Subject: Shoreline Exemption Permit, Pump Station 14 – 4315 Forest Ave. SE.

This is a written response to the review comments provided by the Community Planning and Development Department regarding the application for the Shoreline Exemption Permit, SHL23-003, for Pump Station 14 located at 4315 Forest Ave. SE.

PS 14

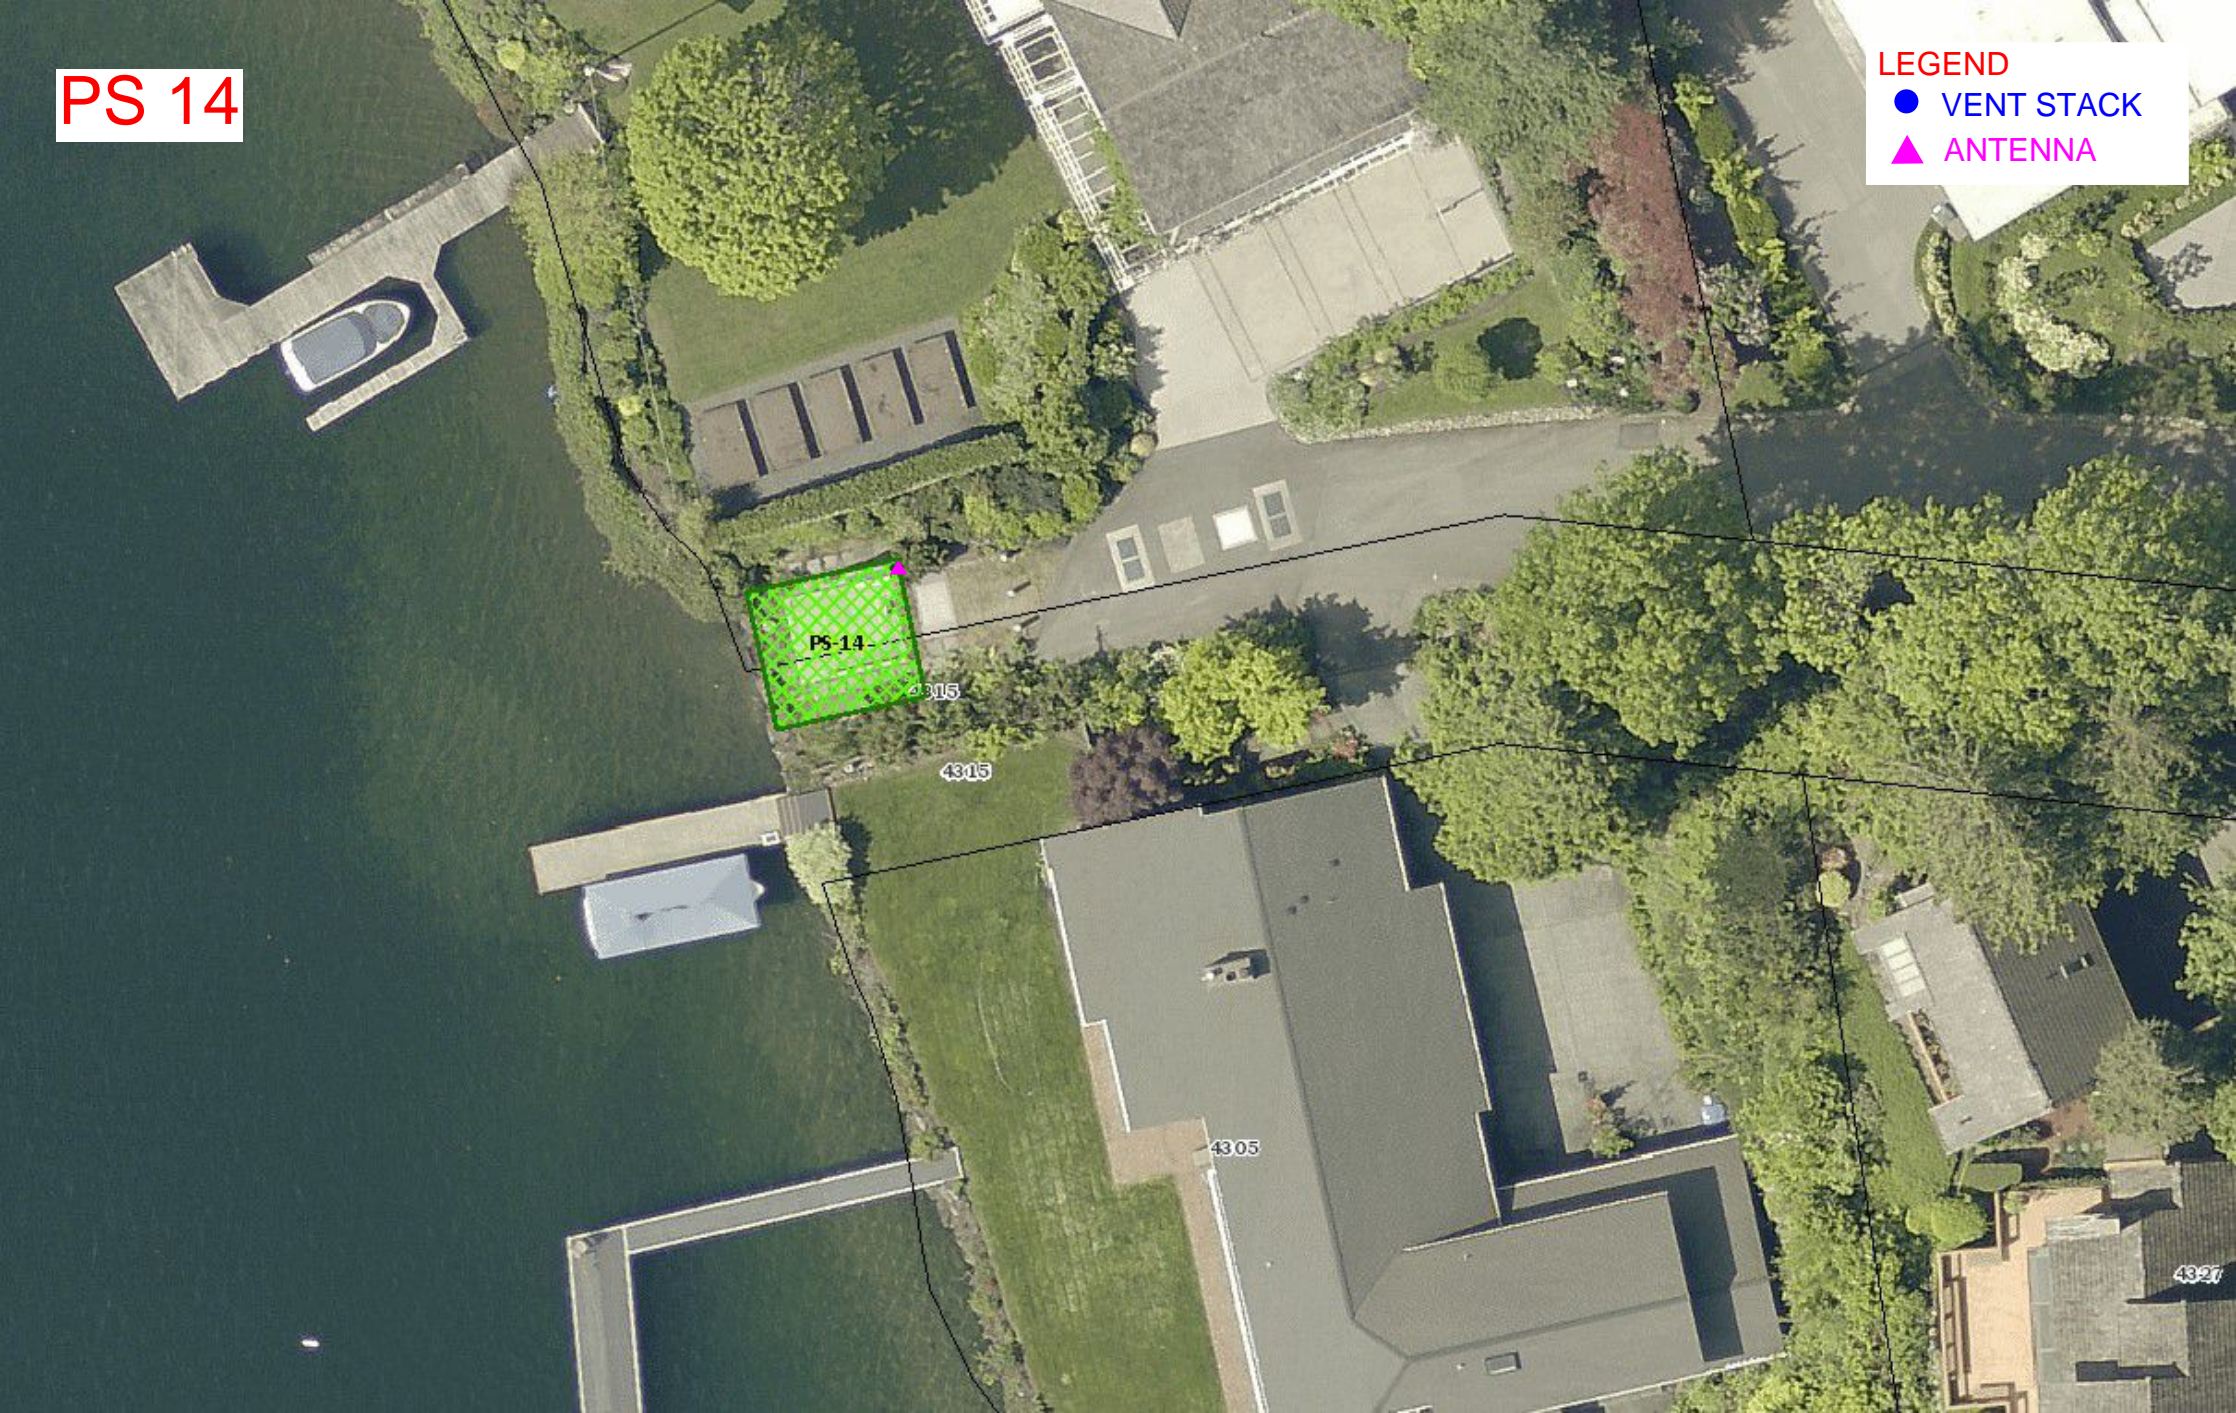
- b. Provide plan of entire site and include distance from antenna structures / proposed developments to OHWM

- c. Include elevations in plan set or call out height on site plan.

Response: *An aerial view photo of the pump station has been provided in the Development Plan set on page 2 showing the OHWM and distances to the antenna structures.*

Response: *An aerial view photo of the pump station has been provided in the Development Plan set on page 2 showing the height and location of the antenna and vent stacks.*

INSTRUMENTATION
PUMP STATION 14 -
PLAN

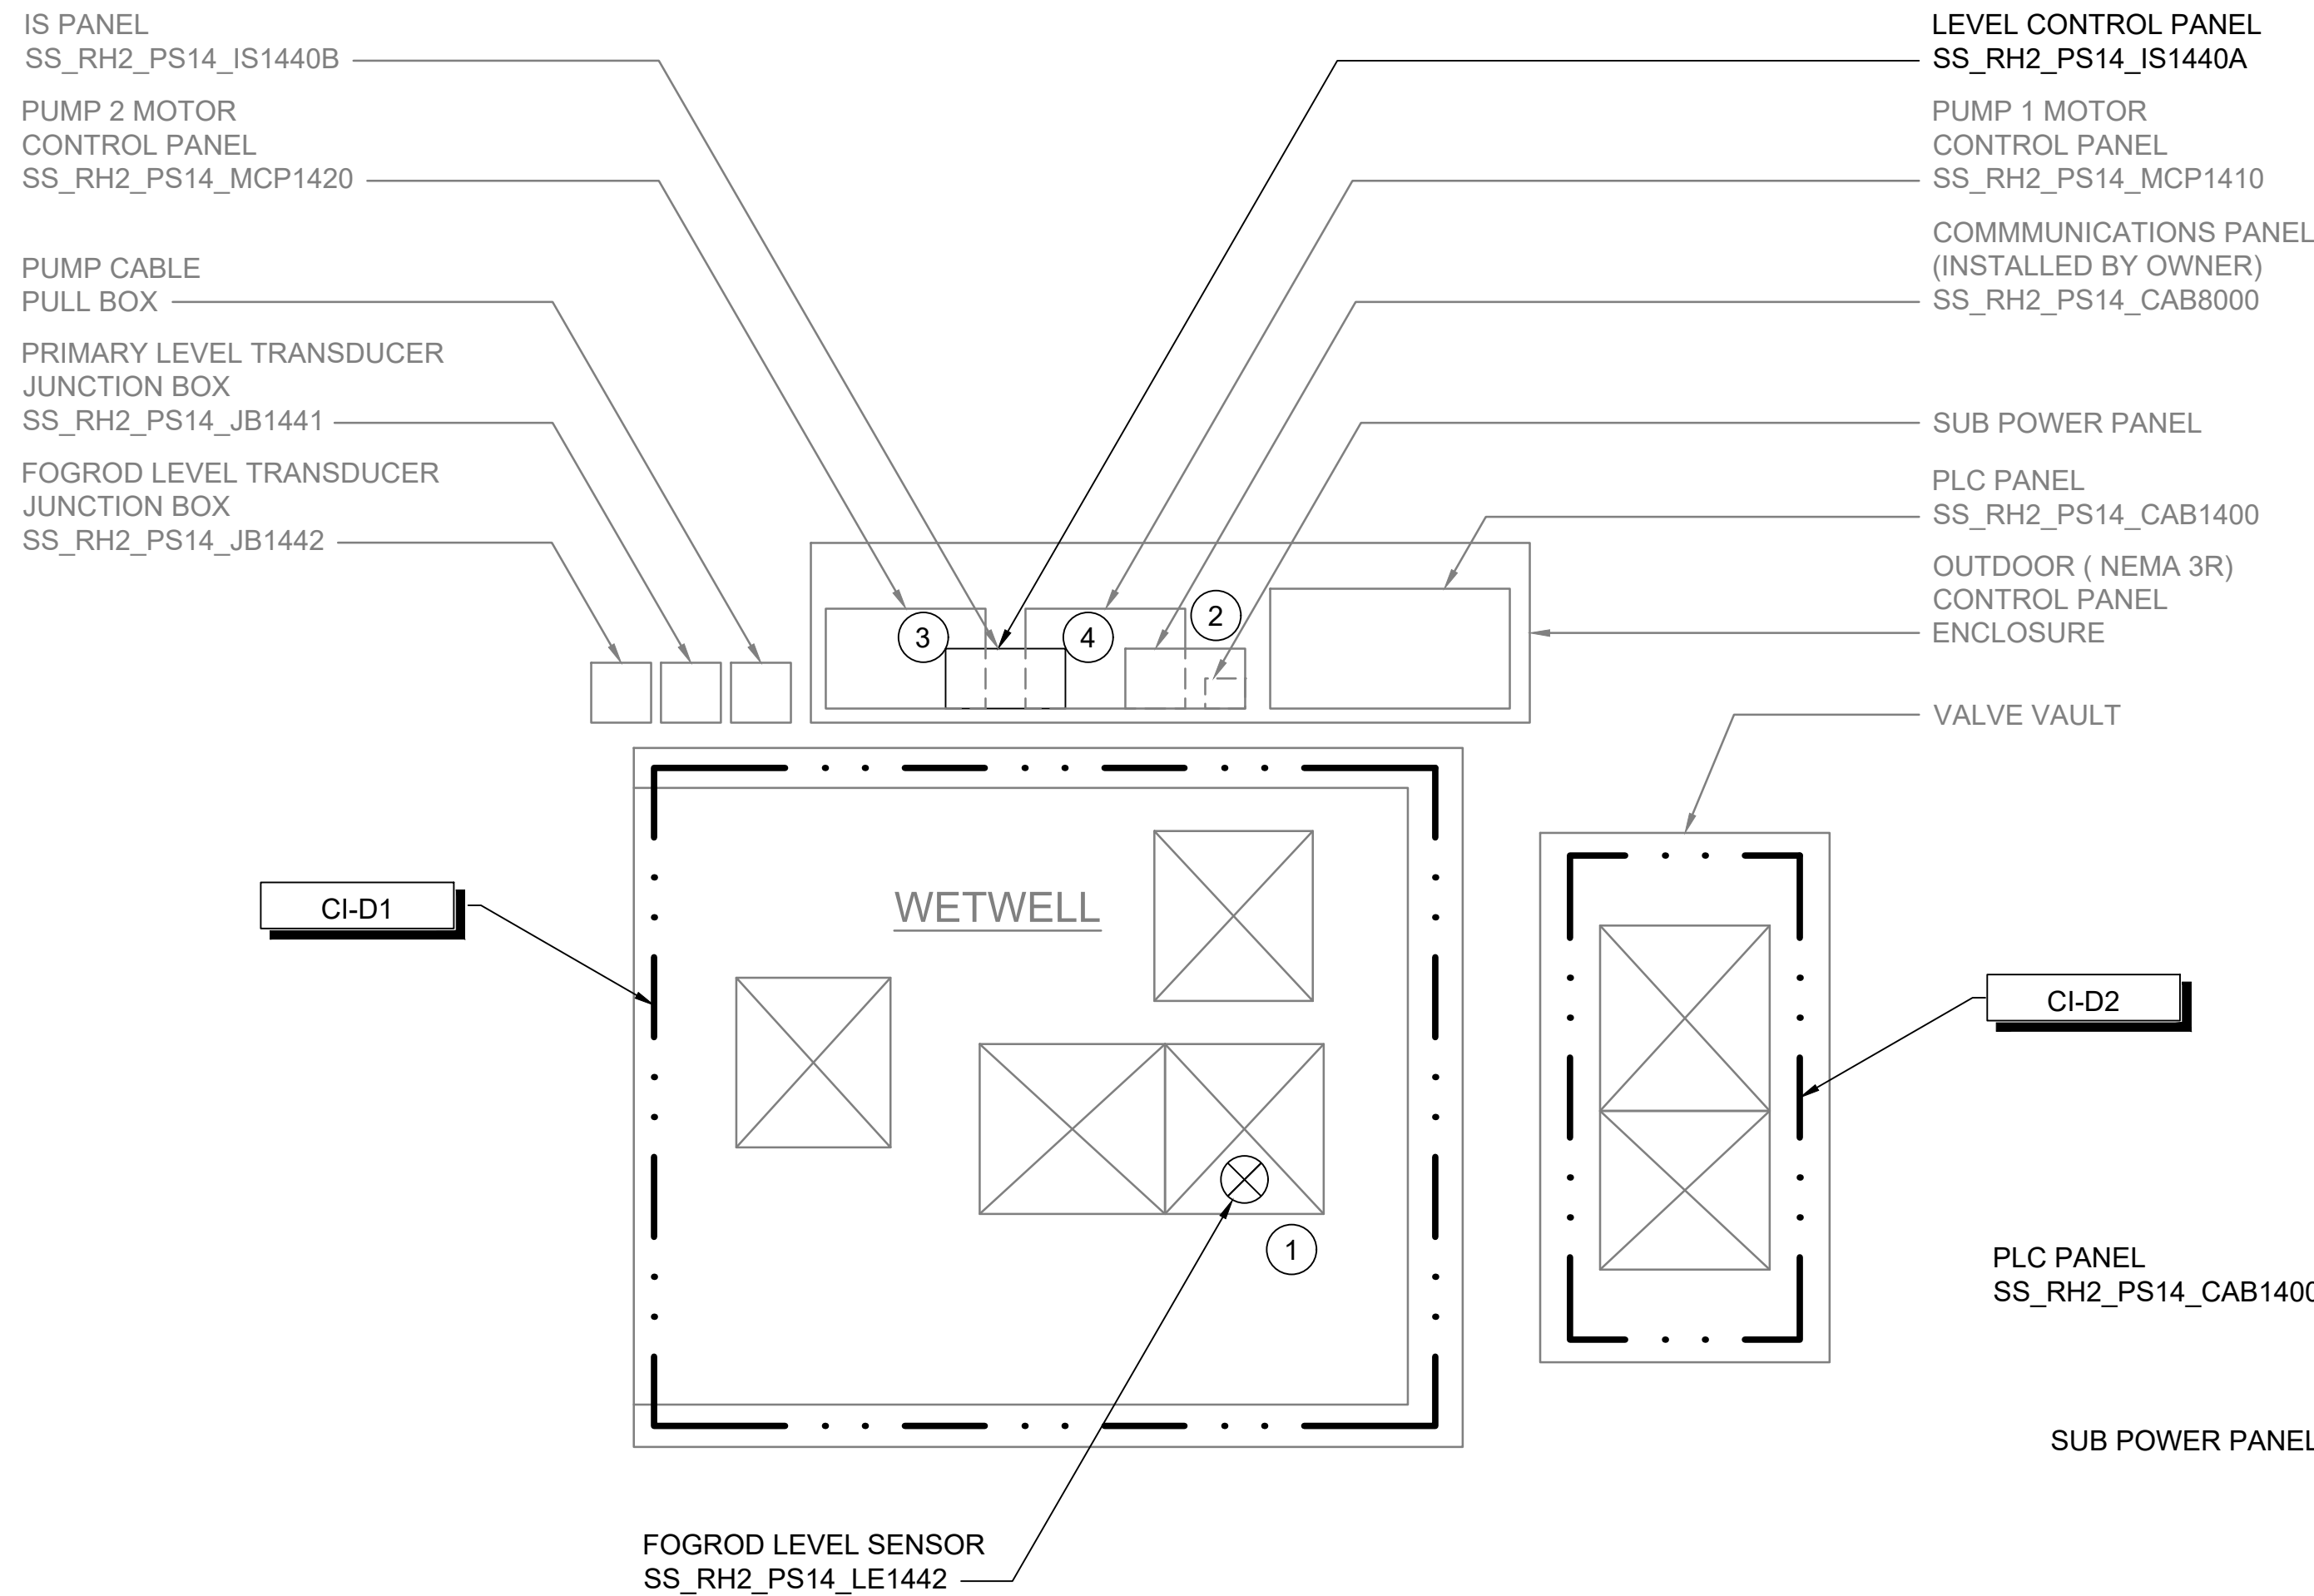
- a. Provide address of all pump stations on plans

Response: *The address for the pump station has been added to Development Plan, Instrumentation Drawing page 1. The address was also included in the aerial photo of the pump station.*
